re: **Geotechnical Design Summary Details**
Proposed Residential Development
5331 Fernbank Road – Ottawa, Ontario

file: PG5683-MEMO.02 Revision 5

Further to your request, Paterson Group (Paterson) prepared the current memorandum to provide a grading, servicing and landscape review for the proposed residential development. The following memorandum should be read in conjunction with the Geotechnical Investigation Report (Paterson Report PG5683-1 Revision 1, dated November 13, 2025).

DRAWING NAME: GENERAL PLAN OF SERVICES

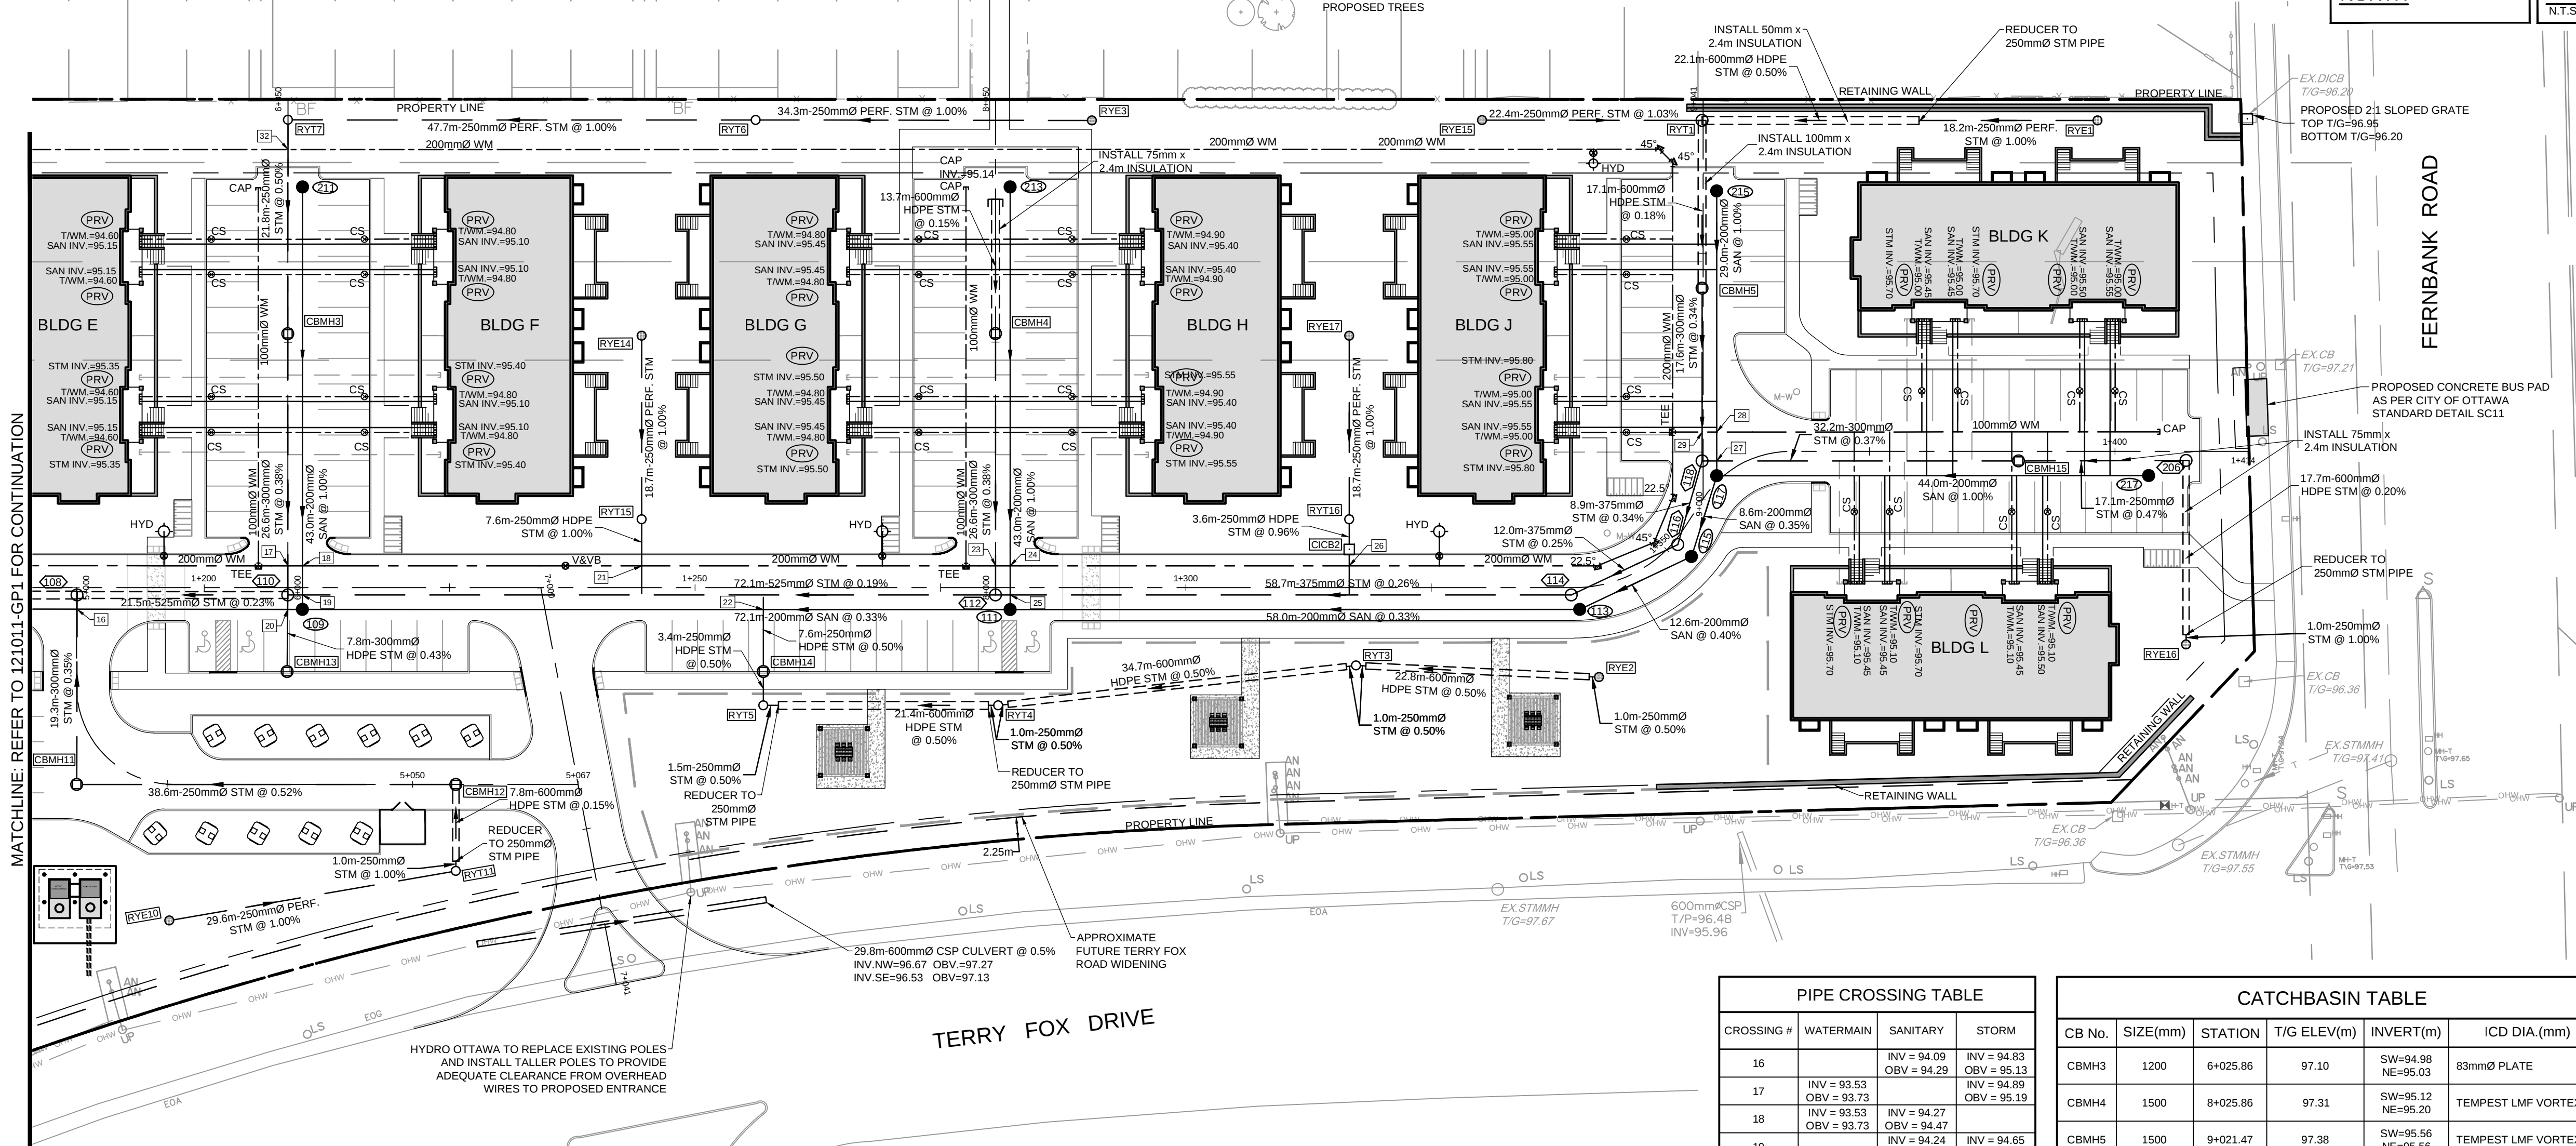
From our review of the above-noted site servicing plan, a number of servicing pipe sections are not provided with sufficient soil cover of 2.1 m for adequate frost protection (measured from the proposed ground surface to the pipe obvert). Reference should be made to the marked-up servicing plans which show the areas with insufficient soil cover, attached to the current report.

For services with less than 2.1 m soil cover, a combination of soil cover and rigid insulation should be used, as detailed in Table 2 on the following page.

Thermal Condition	Soil Cover Provided (mm)	Insulation Dimensions	
		Thickness (mm)	Extension (mm)
Unheated	1800-2000	25	Extend 600 mm horizontally beyond edge of the pipe
	1500-1800	50	Extend 900 mm horizontally beyond edge of the pipe
	1200-1500	75	Extend 1200 mm horizontally beyond edge of the pipe

Alternatively, instead of extending the rigid insulation 600 to 1200 mm beyond the edge of the pipe, the rigid insulation can be “boxed” around the pipe by transitioning from horizontal to vertical placement of the rigid insulation and extending to the invert pipe elevation, effectively forming a box of rigid insulation around the pipe. In this case, the rigid insulation should still be extended far enough to provide adequate spring-line and cover backfill material around the pipe.
